# **STORMWATER MANAGEMENT PLAN (SWMP)**

## **EAGLE FOREST SUBDIVISION**

JPS Project No. 010501  
PCD Project No. SF-21-\_\_\_

SF-21-31

C1

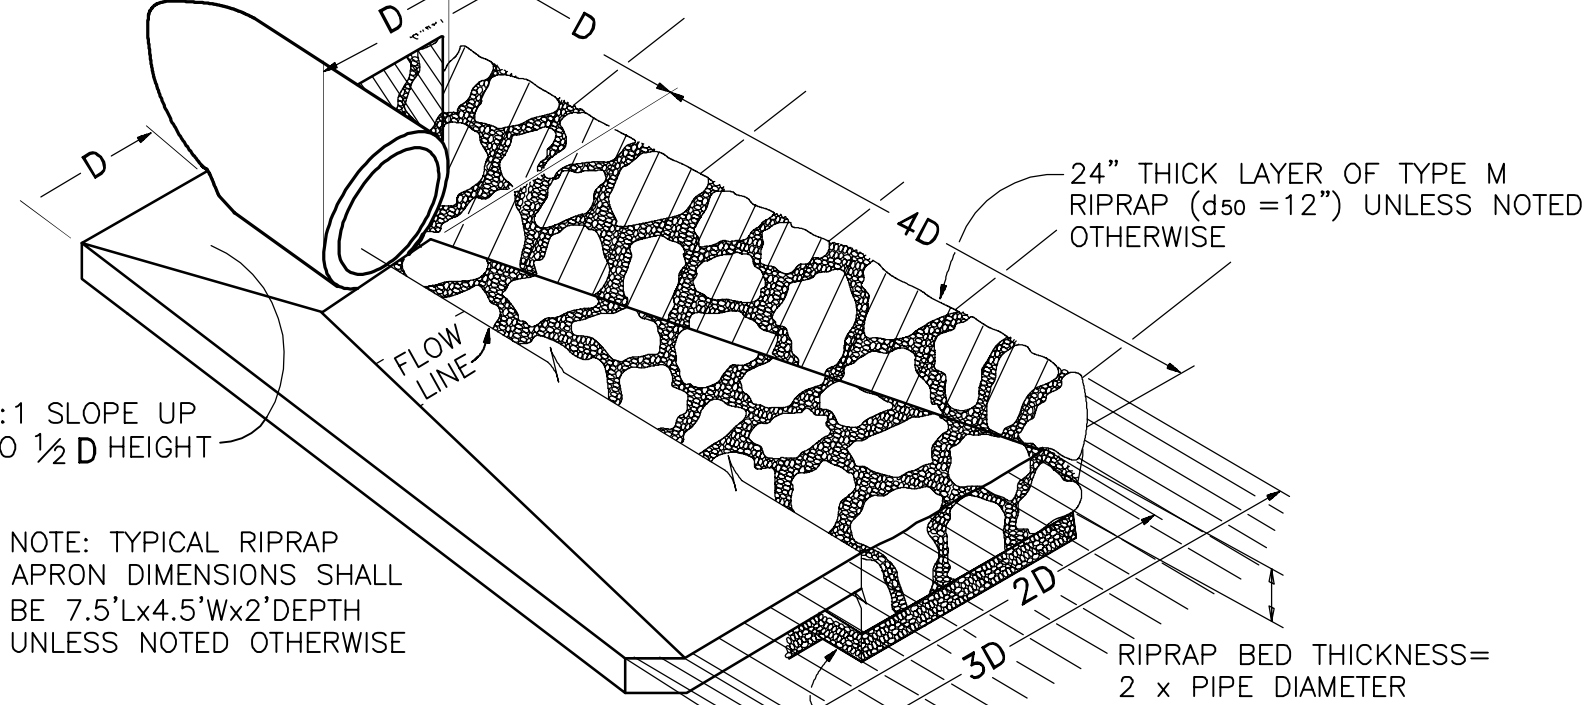
- List phase next to each BMP (like you did on the GEC Plan)
- And include sediment basin
